Great Yarmouth Third River Crossing

RYA's Narrative Case for Issue-Specific-Hearing (ISH-1) (Effect on Port Operations) (Tue-09:00-19-Nov-2019)

Figure 3 – Bridge cross section

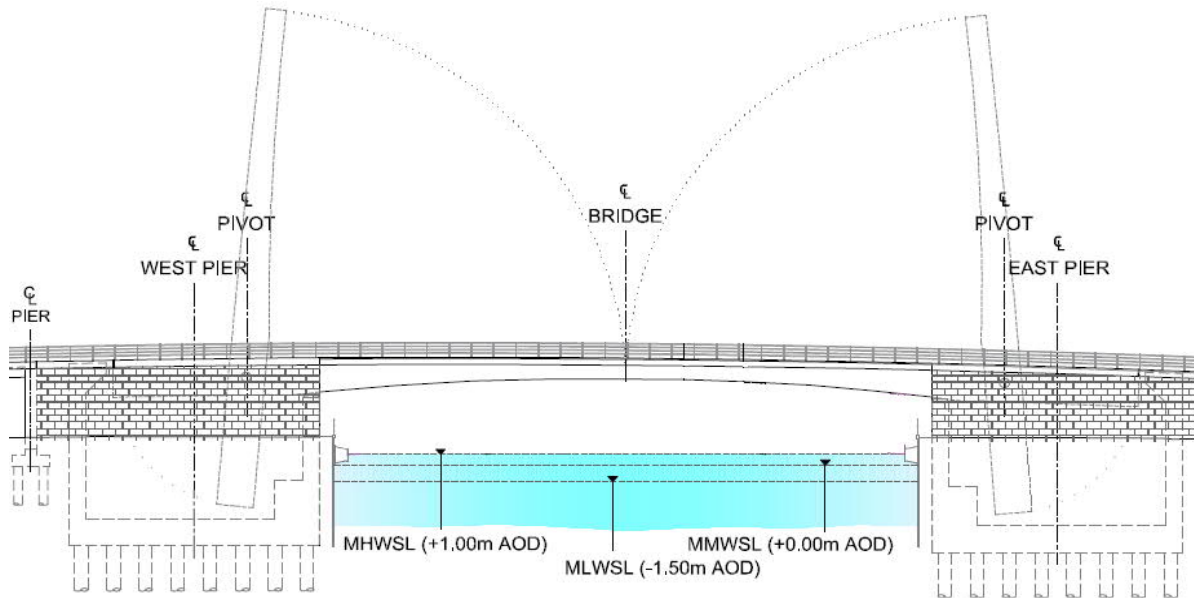
Key Points quoted from pNRA		RYA's Comment
1	2.2.5 The River Yare also provides access to the Norfolk Broads for recreational vessels via Breydon Water. These vessels have to pass two existing lifting bridges, the Haven Bridge and the Breydon Bridge, during a passage between the sea and the Broads.	The River at Gt.Yarmouth is the only natural outflow from The Broads. The older Haven Bridge is subject to frequent breakdown preventing vessels passing The newer Breydon bridge has higher air-draft and does not pose as large an issue
2	3.2.1 & 3.2.6 & 3.2.10 In order to ensure a robust risk assessment process Navigation Risk Assessment workshops have been held to which the principal marine stakeholders were invited	Neither RYA nor any other small-boat stakeholders were invited to workshops in March or September 2019
3	4.5.8 Vessels with projections ... are at greater risk when passing through	Bridge fendering shown as individual cones

Yachts in particular are at risk of catching rigging on individual fenders;
Continuous fenders would provide mitigation

Figure 11 – Hydrodynamic Model Comparison

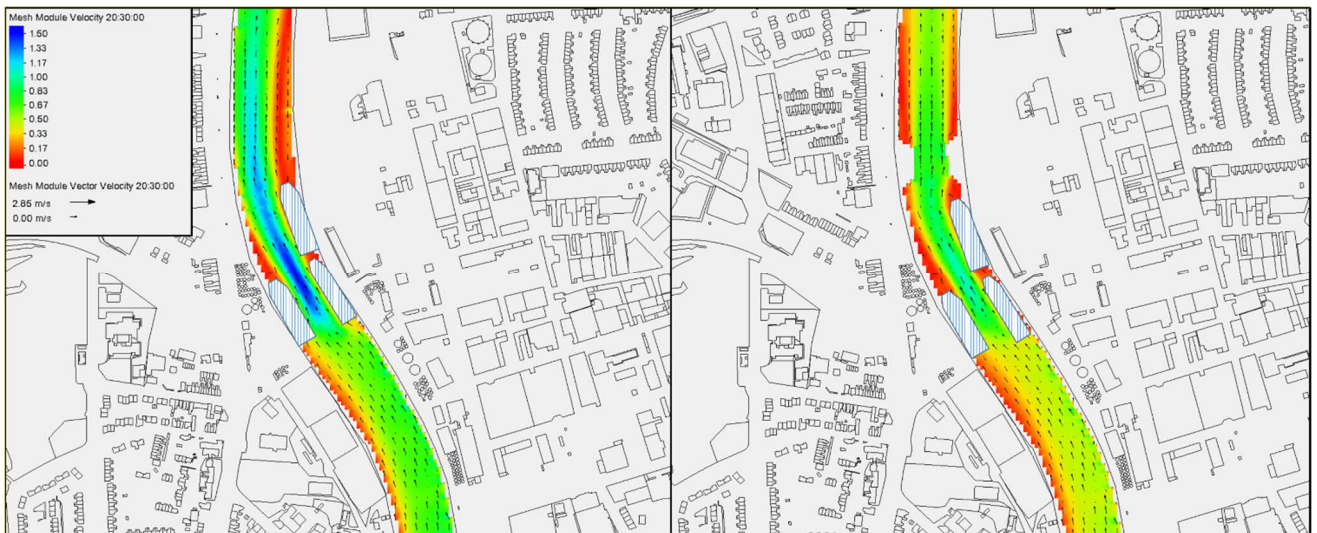
Key Points quoted from pNRA		RYA's Comment		
16	App.D 5.8	The abutments are also more abrupt than the bow or stern of a vessel, so the effects of the current through the bridge is expected to be more marked than present conditions, even when vessels are berthed on both side of the river. The acceleration of the flow and the change of direction near the abutments is also expected to be greater than that currently experienced. In short the bridge is likely to make Navigation more challenging than is currently experienced	Issues with acceleration of flow and change of direction are predicted within the immediate proximity of the abutments	This is exactly where waiting pontoons for small boats are envisaged. The additional risks identified here are nowhere else applied to small boats approaching or departing the waiting-pontoons.
17	App.D 6.5.1	Once the bridge opens, waiting yachts & pleasure craft should transit the bridge first to reduce obstructions on the waiting berths near the bridge.	The situation appears to consider waiting craft and passing ships both travelling in the same direction.	It is considered of increased risk for small boats and ships intending to transit in opposite directions . Proposed operating procedures do not appear to take this into account.

18	App.D 6.5.2	Consideration should be given to methods of reducing the rates of change of both current strength and direction close to the bridge	This is close to where the waiting pontoons are envisaged. Mitigation of risk for passing ships by streamlining the abutments is a consideration.	The consideration stated does not transfer to small boats; this is a serious omission
19	Simulations 3	The bridge has three spans comprising two fixed side spans and a central span with a twin leaf bascule, supported on two main piers. These are located with "knuckle" structures in the river, which are protected by fendering, in the form of super cone fender units as shown in Figure 3.2	Particularly, the abutment fendering is of an individual-cone system	Individual cones present an added risk especially for yachts which might catch their rigging; continuous smooth fendering would be preferable. This is addressed by The Applicant in the SoCG as a recommendation for consideration.
